Our ref: Redfern Mixed Use Co-living Development-Mod-2 (SSD-32275057-Mod-2)

Subject: Response to Submissions

The exhibition of the modification report for the Redfern Mixed Use Co-living Development-Mod-2 (SSD-32275057-Mod-2) ended on 16 Mar 2026.

Figure 4 Proposed Basement Plan

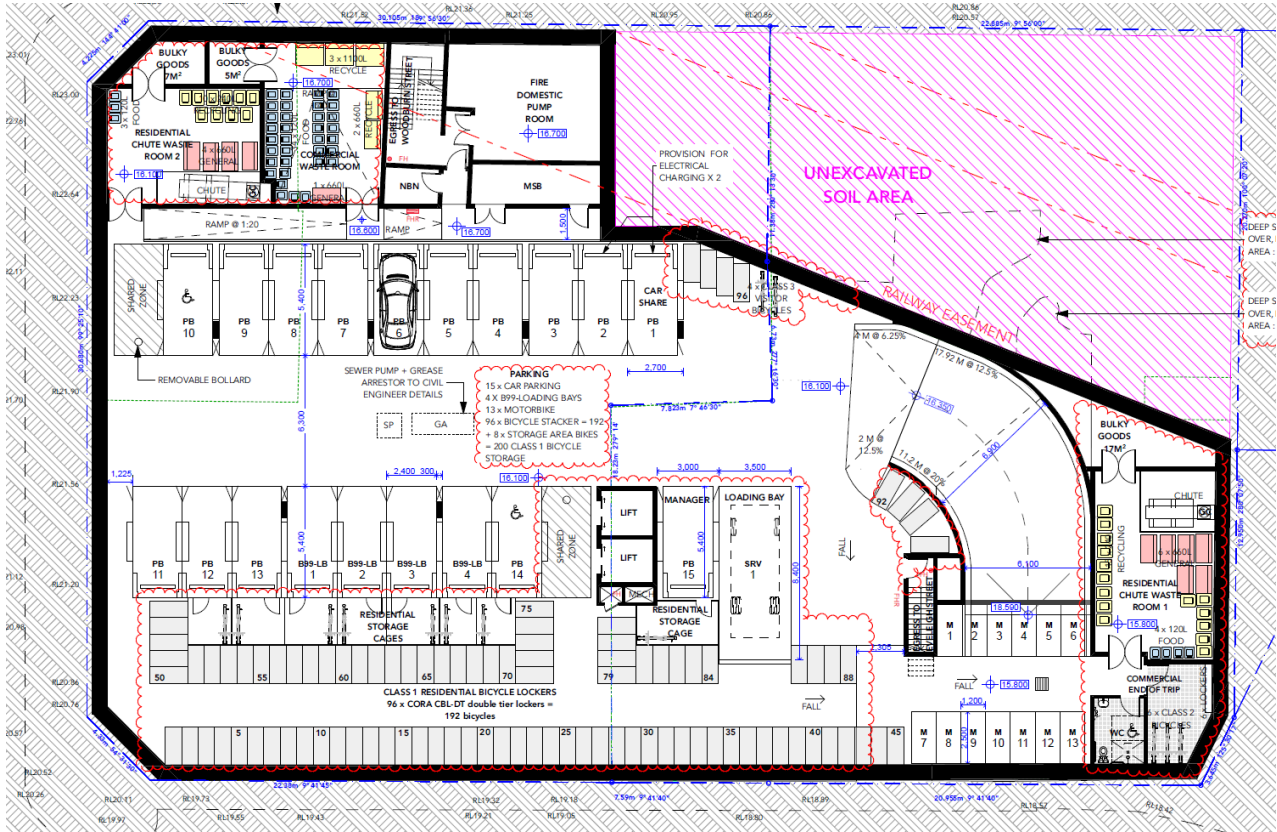
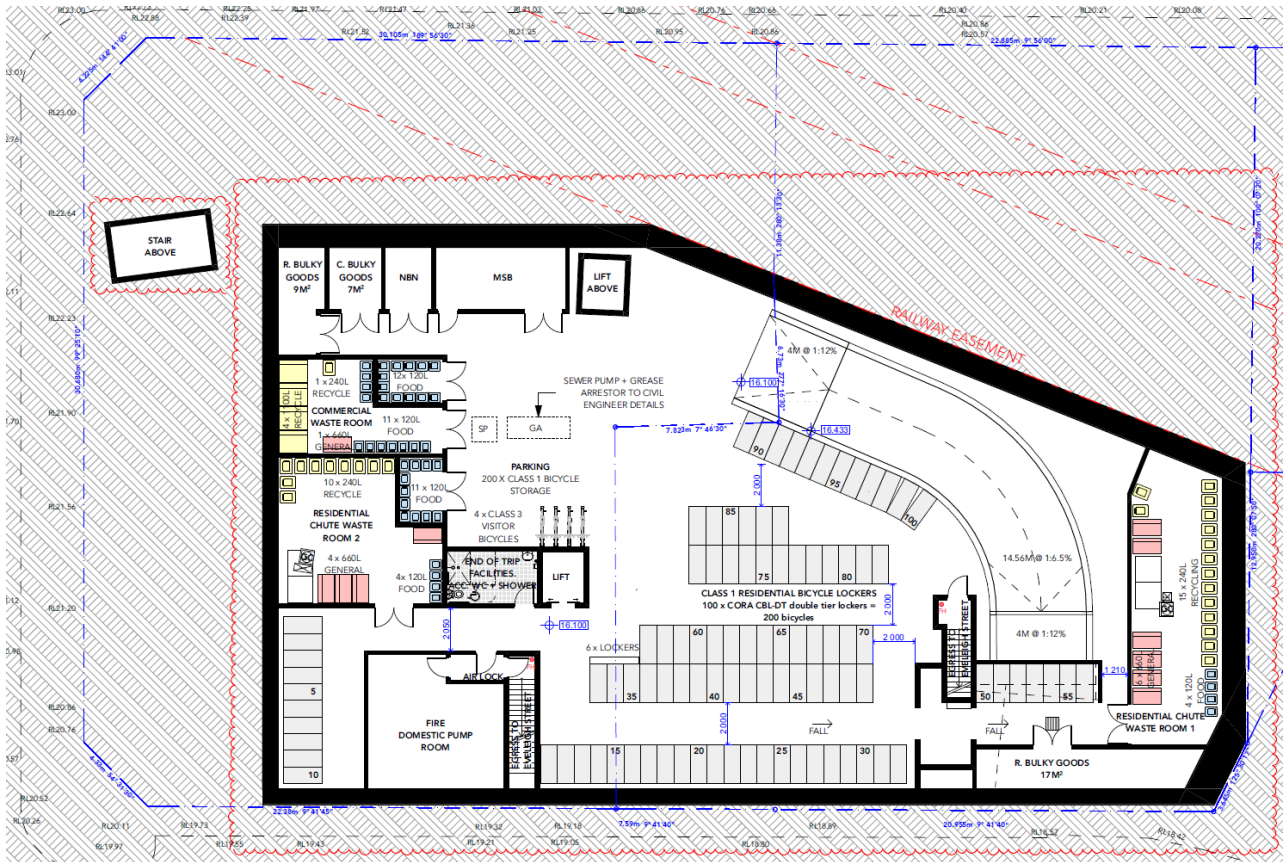
4. Consider opportunities to accommodate Council standard waste collection as a result of the proposed changes to the basement layout, including the provision of a dedicated / marked loading bay for service vehicles.
